Recommendation Report for Planning Permission for Works or Extension to a Dwelling

REF NO: M/100/24/HH

LOCATION: 1 Elmer Court
Elmer
Middleton-on-Sea
PO22 6JT

PROPOSAL: Single storey rear pergola and first floor rear balcony with sliding doors. (Part retrospective).

BAR/103

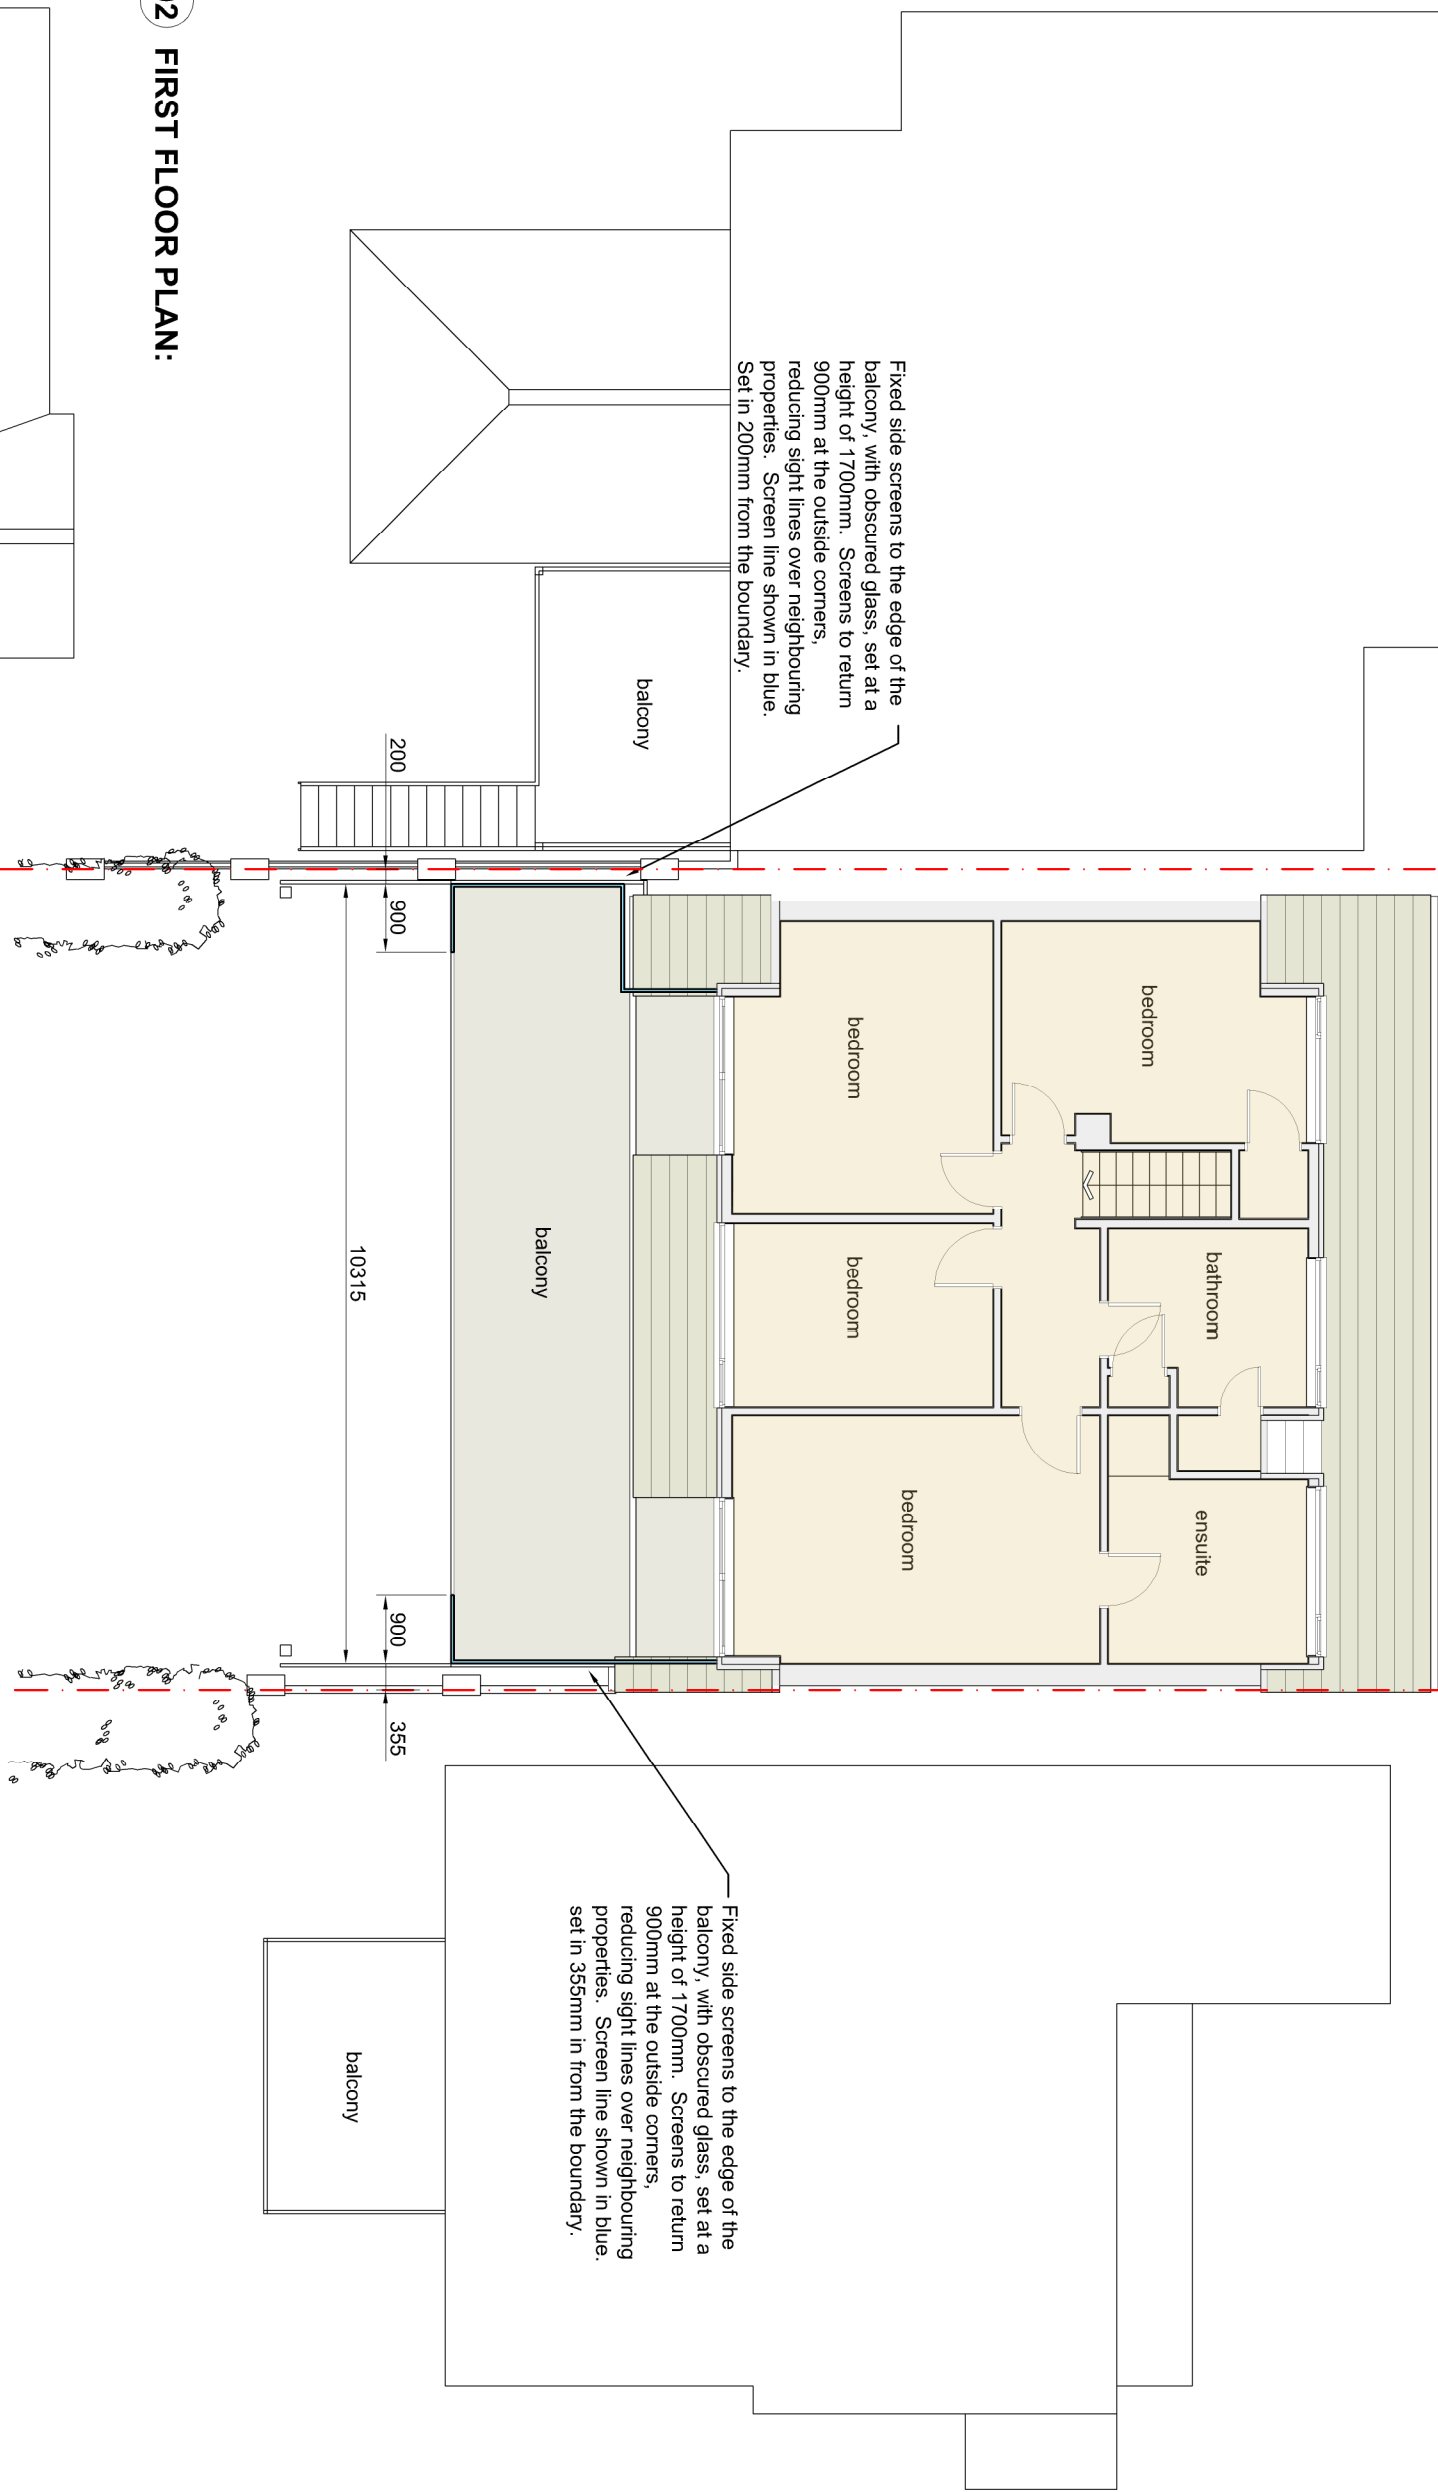
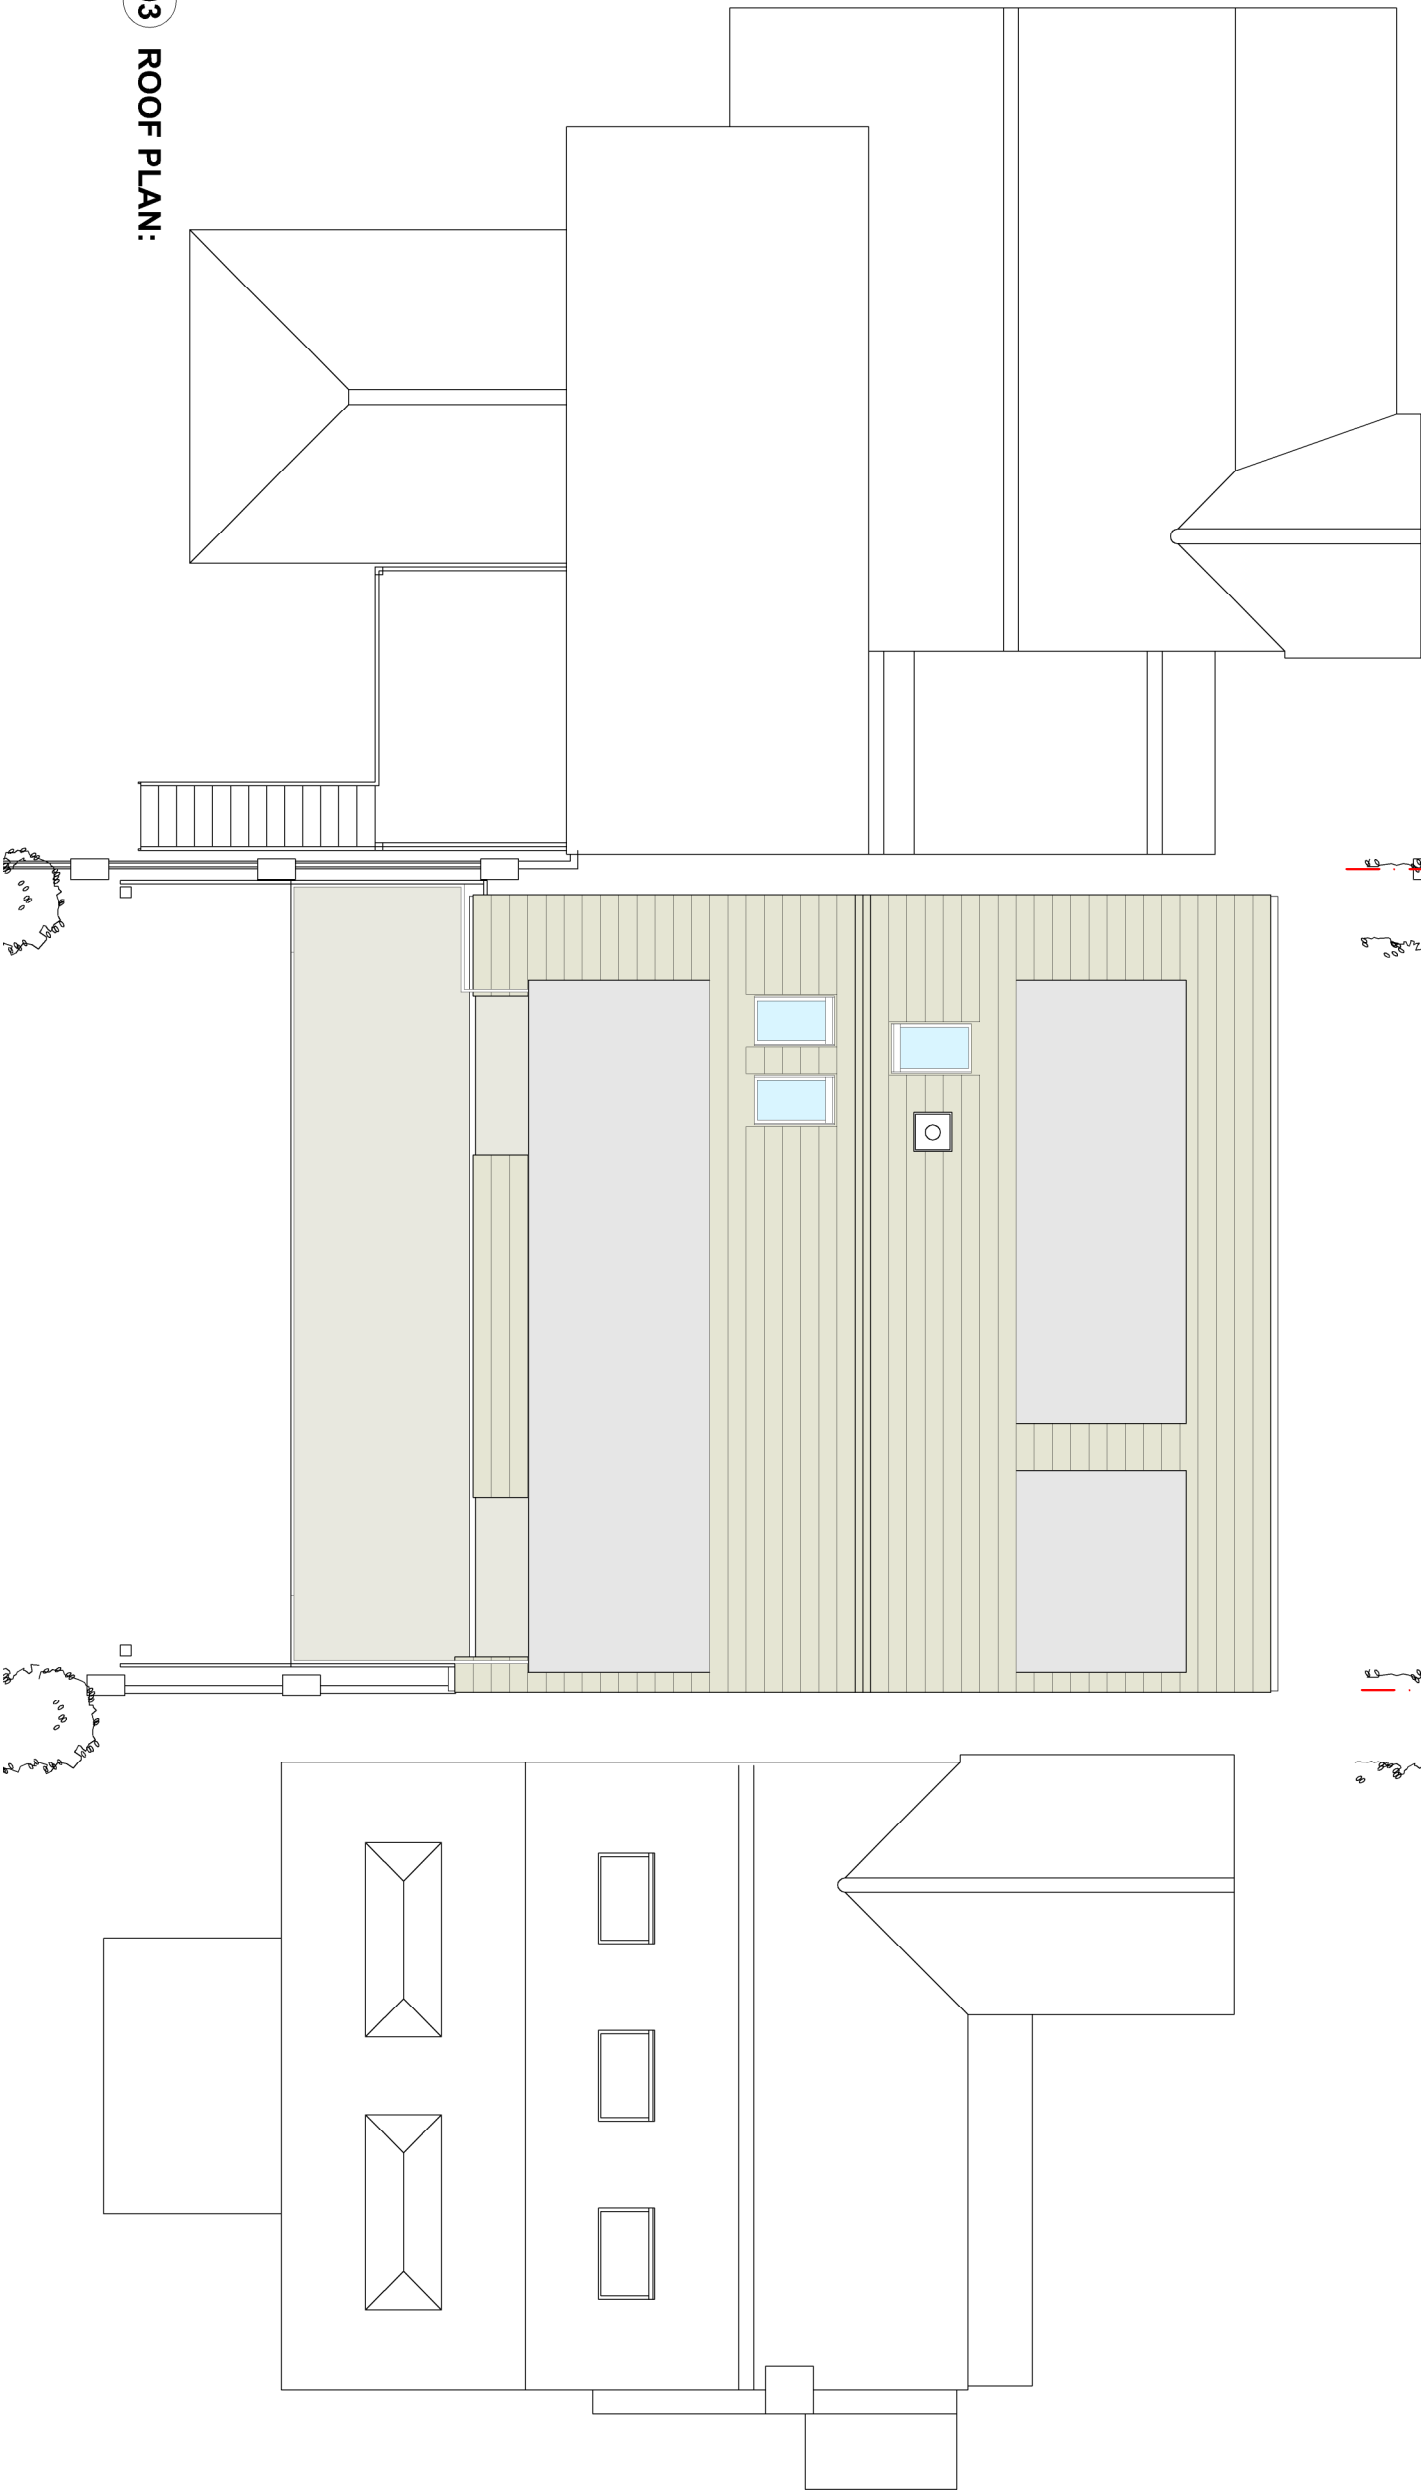
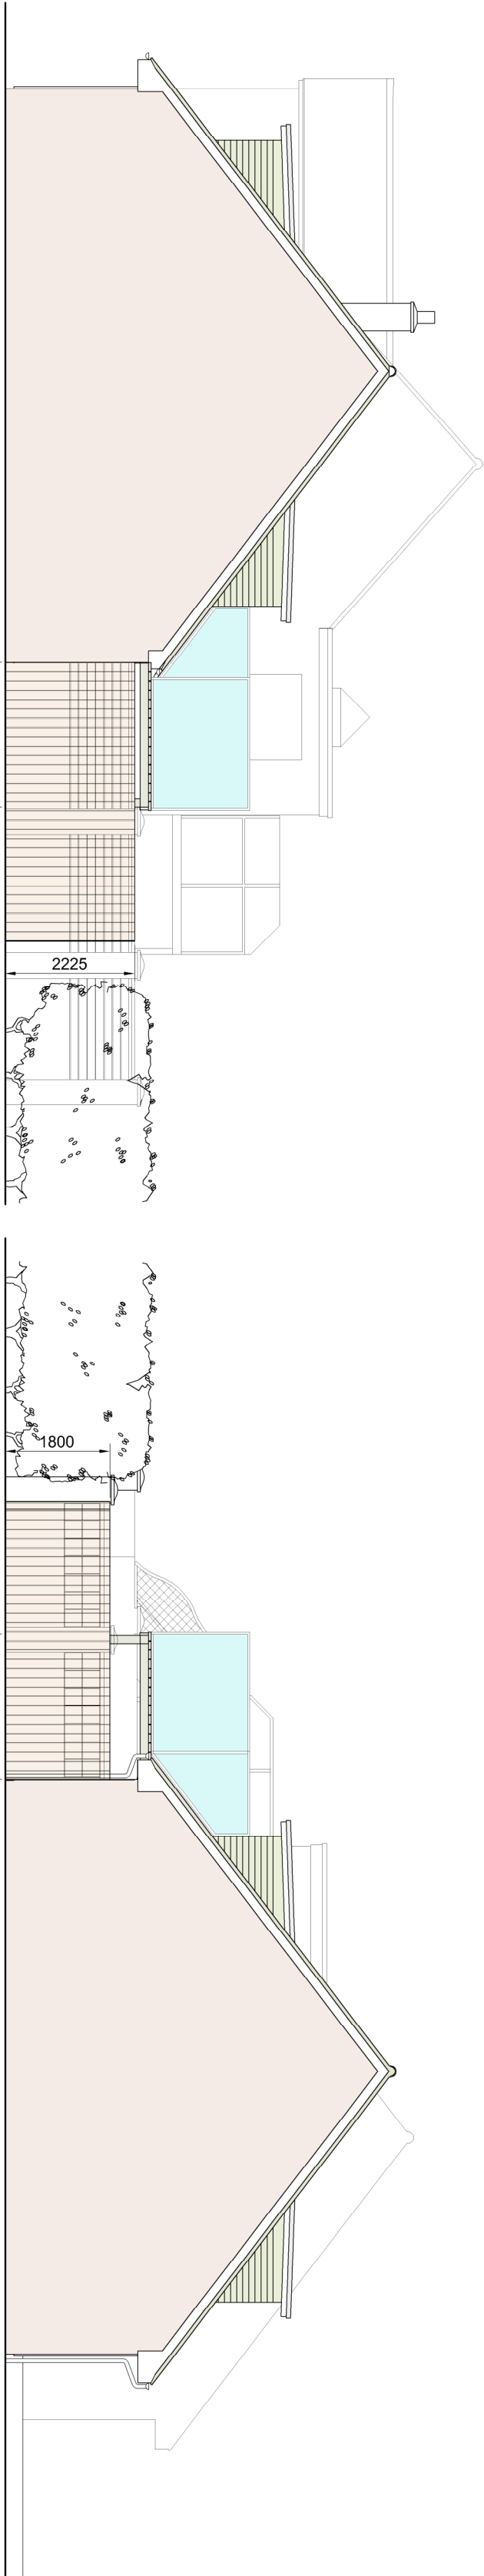
The balcony would measure 5m in depth and it would extend along the entire width of the dwelling (approx. 11.2m). It is noted that there are 2 sets of casement windows to the rear elevation of the house which serve the bedrooms of the property. It is proposed to increase the windows serving the bedrooms to allow for 2 sets of patio doors. Objections have been received from nearby occupiers stating that the proposal would be out of character with the area and that the scale of the proposal is overbearing. On discussion, plans were amended to reduce the depth of the balcony to 2.7m.

It is accepted that the amended plans would be an improvement on what was initially proposed. Due to the submission of inaccurate site plans it is not possible to fully and accurately assess the impact of the development on the host dwelling or wider area. A 1.8m wood panel side screening is proposed at first floor level, the wooden panelling will appear extremely overbearing in its context and will alter the character of rear elevation of the dwelling significantly.

In terms of overlooking, the first-floor balcony by virtue of its size and location when in use will give rise to significant overlooking of neighbouring properties. The balcony will offer direct views into the rear gardens of neighbouring properties. To counter this, a 1.8m high wooden panelling is proposed on both sides (east and west) to protect the residential amenities of neighbours and mitigate any overlooking. However, this screening would result in a scheme detrimental to the character and appearance of the host dwelling contrary to D DM4 of the Arun Local Plan (ALP).

The two sets of patio doors proposed on the rear (south) elevation at first floor level will not have any additional overlooking impact as these are proposed in the same location as additional windows and are acceptable.
